D1 Submission: Design Concerns.

D1 Submission: More Concerns.

- Order Limits:
- Cable Corridor:
- Cable Corridor Option:
- Indicative HDD Entry / Exit Pit:

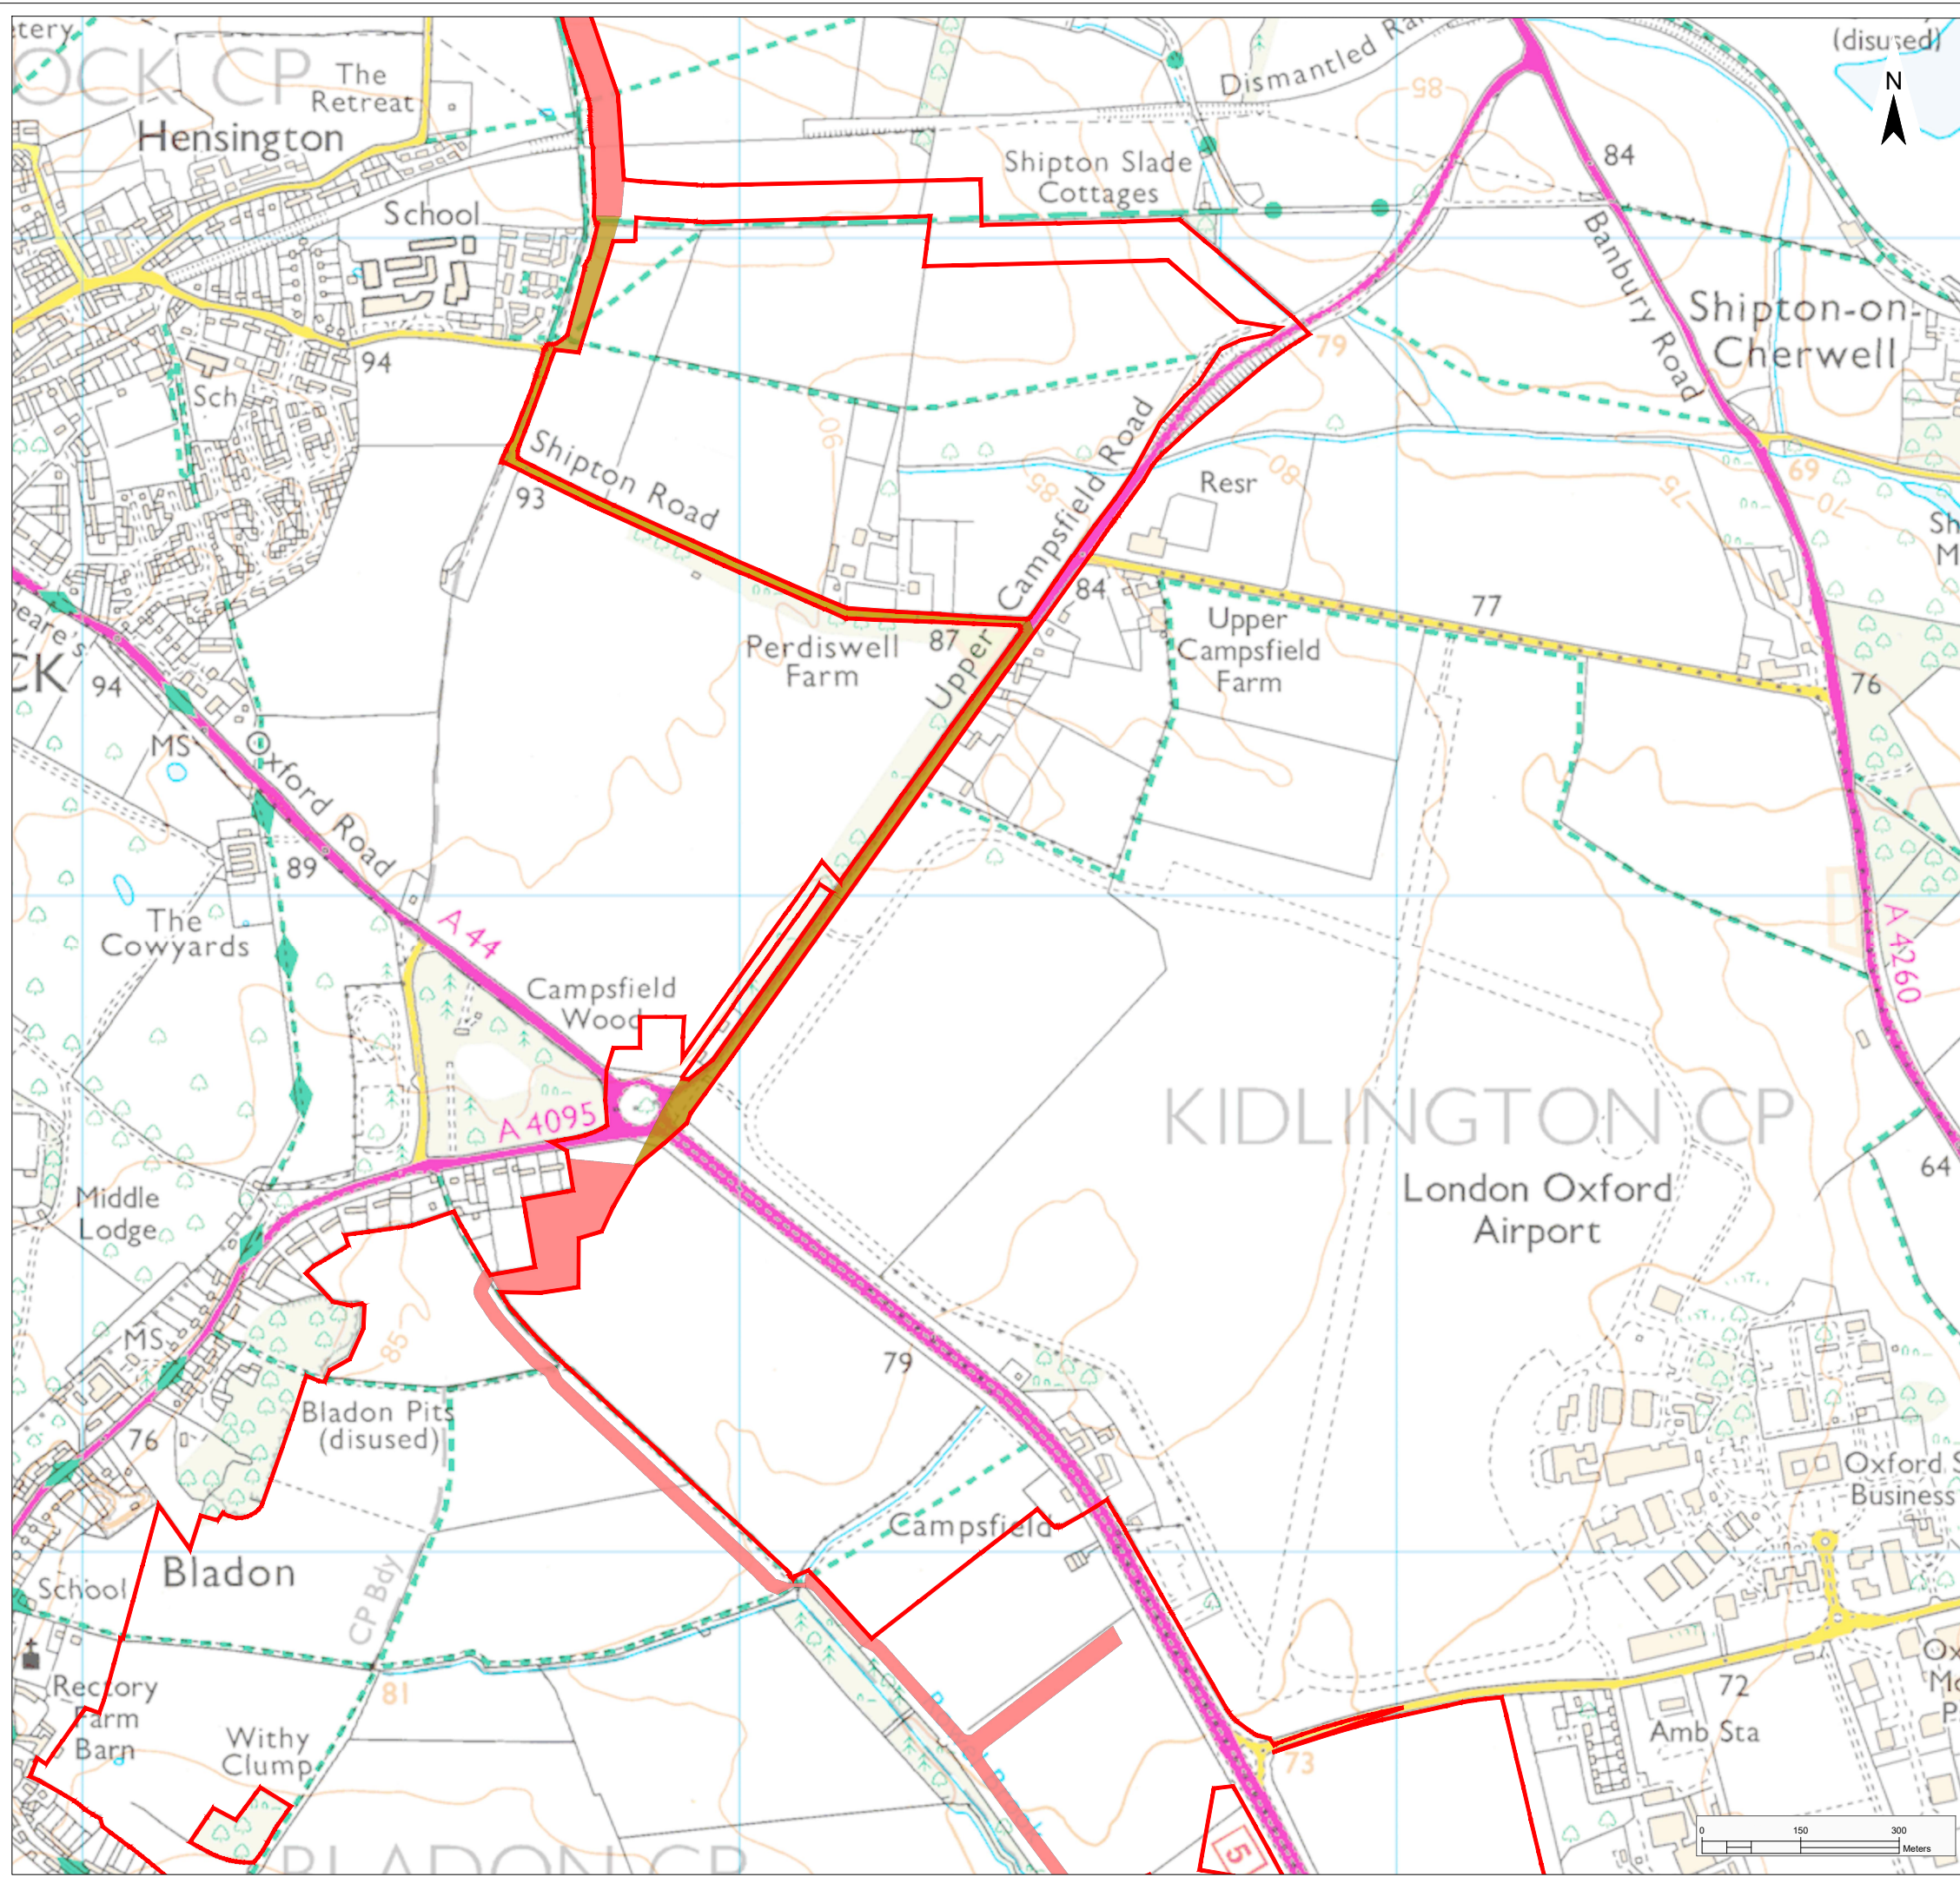
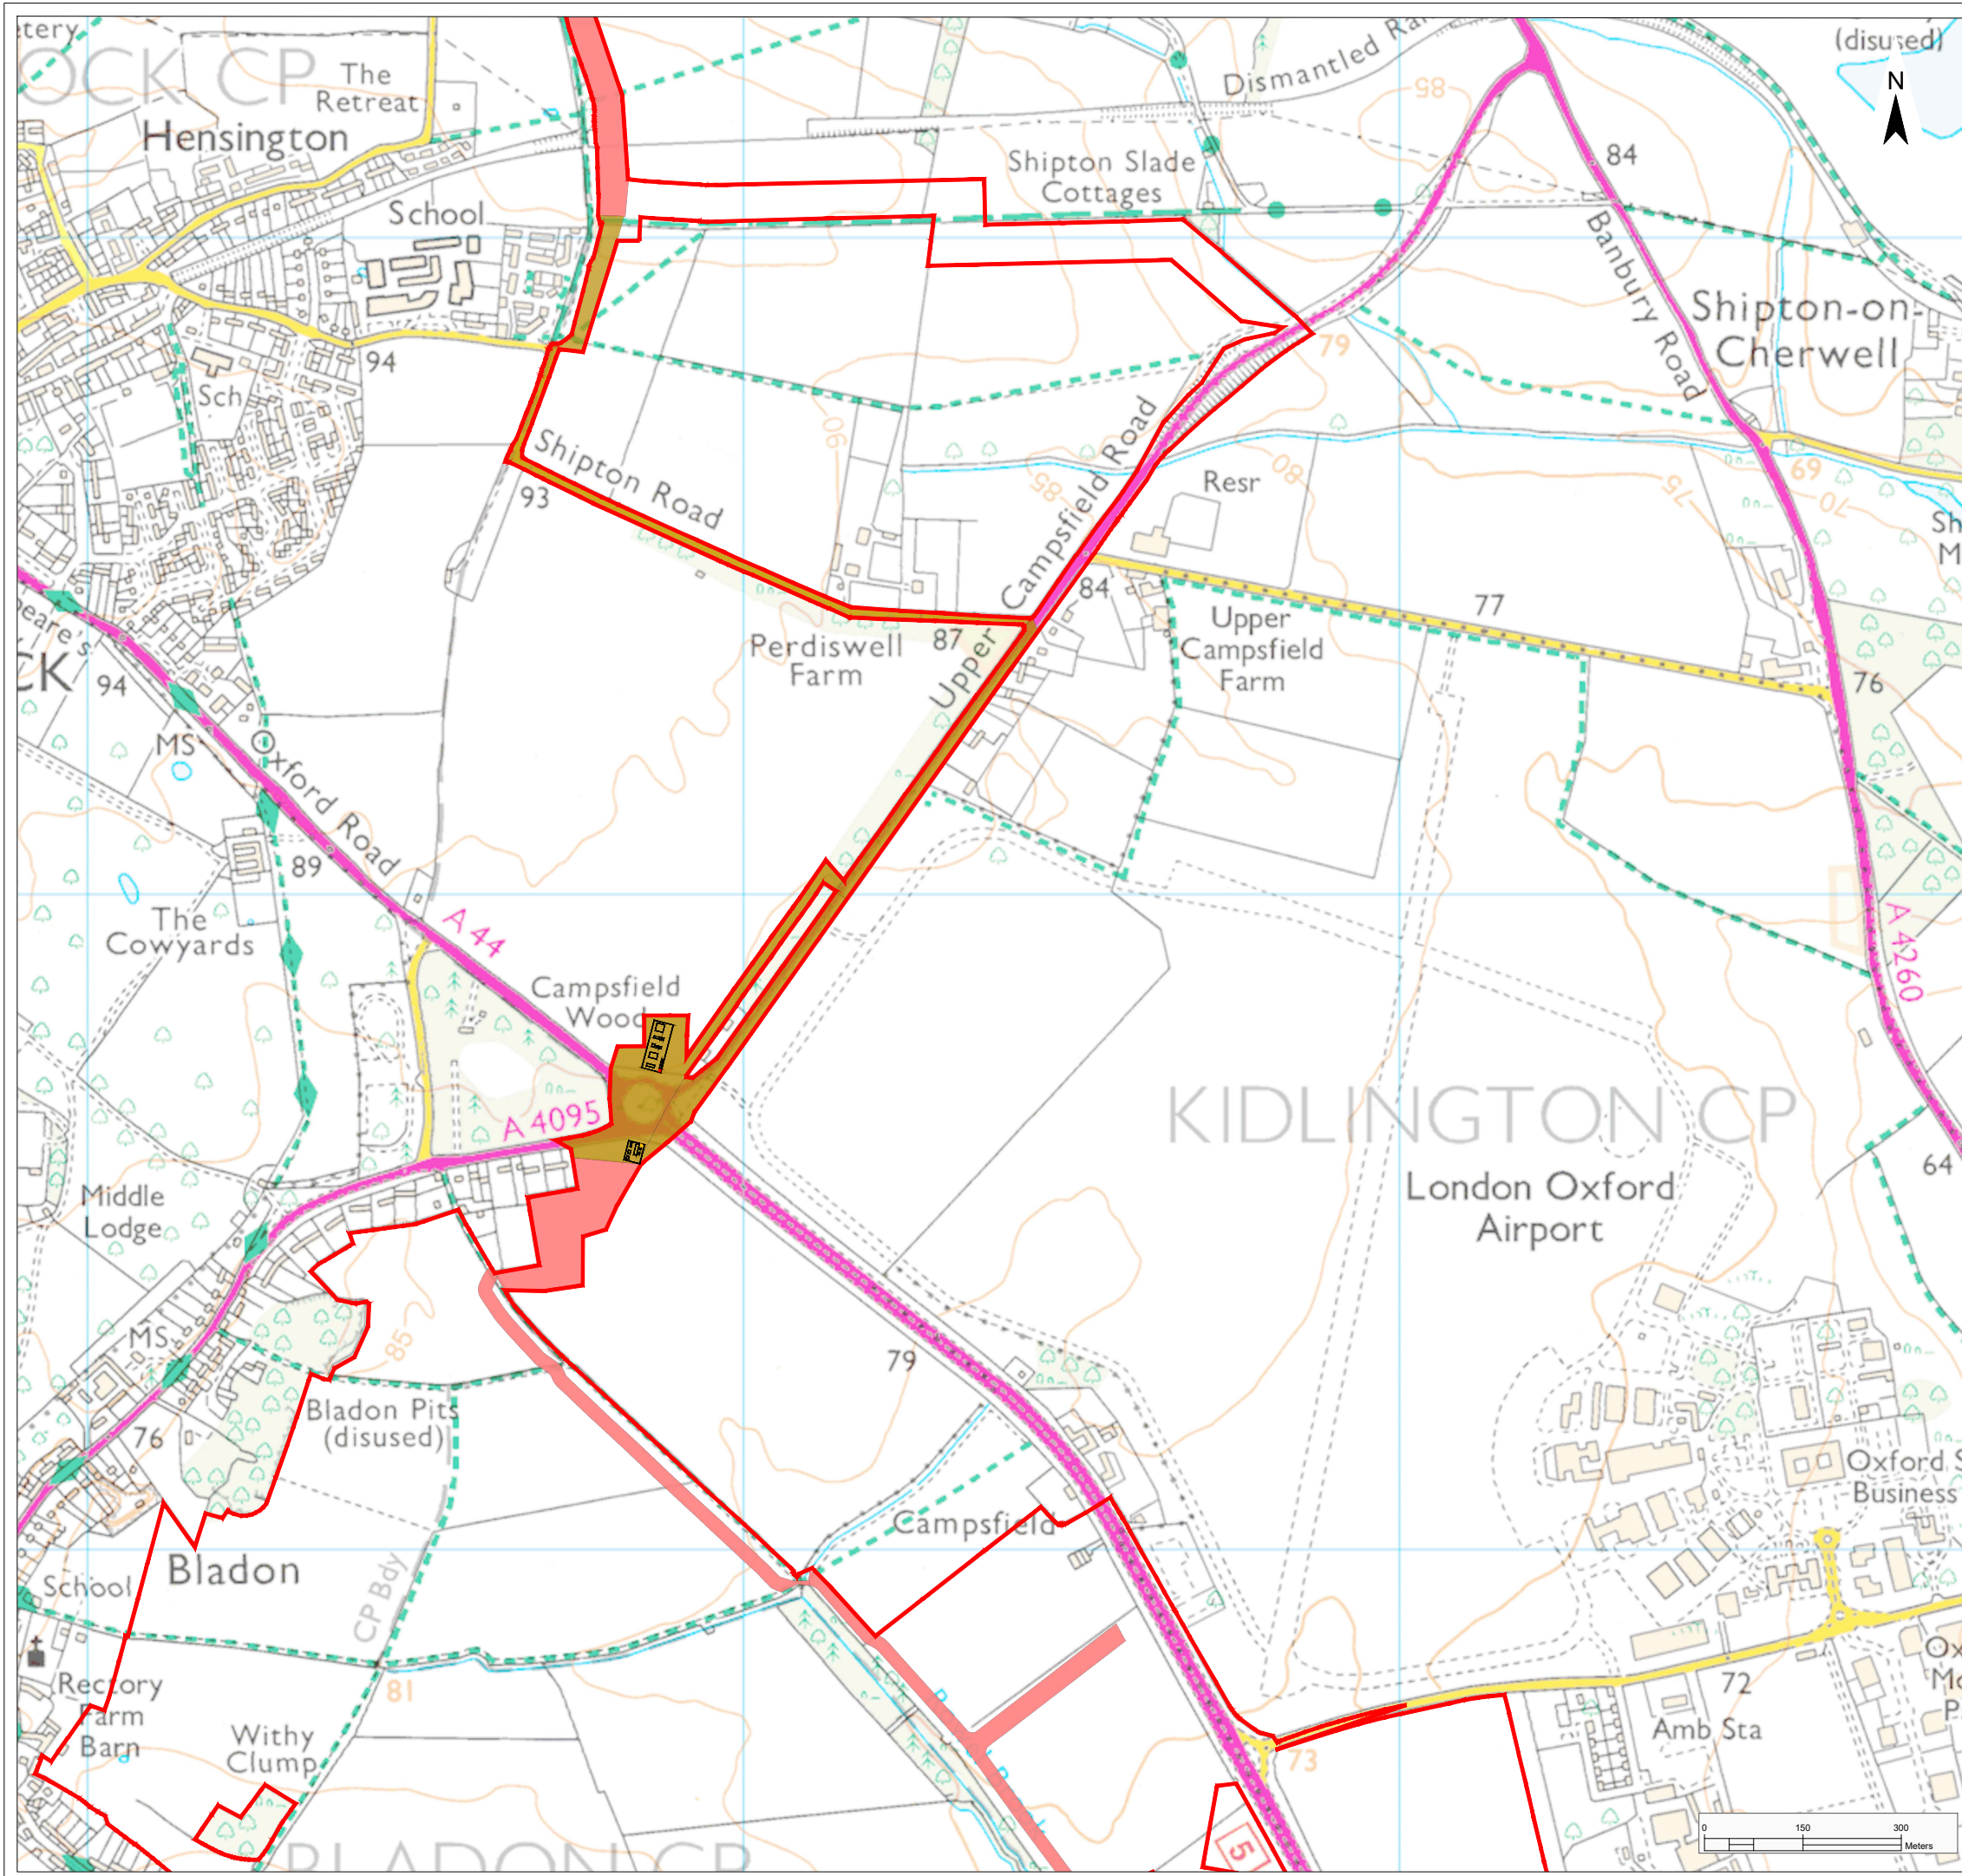
According to Table 6.3 of ES [Project Description](#) the scheme will have between 1,800,000 and 2,200,000 PV panels. This is somewhat lower than the range previously anticipated in the [Scoping Report](#) (Table 6.1) at 2,500,000 to 2,800,000. As a provisional [Illustrative Masterplan](#) has now been drawn up, what is the Masterplan panel count?

Zooming in on the Masterplan confirms that a 'standard' table comprises 26 PV panels in portrait configuration (13×2) as described in the Scoping Report. (Project Description omits the standard table.) This is consistent with the dimensions of the Longi LR5-72HGD panel ($2278 \times 1134\text{mm}$) specified in Table 14.7 of ES [Climate Change](#).

1) There are many ultra-short tables (e.g. **1** and **2** in the diagram). The Scoping Report gave a minimum table length of 14m. Project Description reduced this to 3m. Table **1** looks like a single panel width: 1m.

A brief survey on Google Satellite suggests that no tables on UK farms are less than 8m. Are these ultra-short tables drawn in error, or is PVDP pushing the envelope on table design?

2) The Masterplan also shows the network of roads (**R**) than run around the perimeters and across the fields. These are coloured grey here but are described as 'grass with occasional matting' or 'natural ground surface' [[OOMP](#), p6]. Are these sufficient to support the weight of emergency fire tenders year-round? Has Oxfordshire Fire and Rescue been consulted? The roads look a bit narrow for the job (2.5m), and the turn radii are certainly far too tight to be negotiated by a fire tender. Should some panels be removed to relax the radii?

How will a replacement PCS be delivered to its location? These are the size of a standard trailer unit [[Project Description](#), Table 6.3]. An articulated lorry plus crane would be unable to reach their destination on BWSF's internal roadways.

3) The north-south table gap is specified in Project Description as between 1.5m and 3.0m; the gaps measured on the Masterplan are 1.5m (panel:gap ratio 3:1).

This is considerably narrower than the 4.0m gap that one sees typically in the UK. At lower latitudes tight spacing might be acceptable, but up here at 52°N the sun never gets very high: tight spacing will result in excessive energy loss for much of the day due to self-shading (shadow from the adjacent row of panels to the south).

4) Similarly, Table 6.3 of Project Description specifies a minimum distance of 7m between the fencing and the solar tables, whereas the Illustrative Masterplan shows PV panels consistently packed in with a fence separation of less than 5m.

Is this an interim layout subject to revision upon further critical review?

An appealing feature on the [Illustrative Masterplan](#) is the inclusion of Skylark Plots, shown as brown squares, within the solar arrays. These are described in section 11.6 of [Outline Landscape and Ecology](#), and broadly follow the guidance in the government's set-aside compensation scheme [AB4: Skylark Plots](#). ("Unsown plot" in 11.6.3 presumably means an area not 'sown' with solar panels.)

The Landscape language is similar to that of AB4, with the exception that PVDP calls these 'foraging areas' rather than the nesting sites intended by AB4. The 50m rule is not observed in the Masterplan drawings.
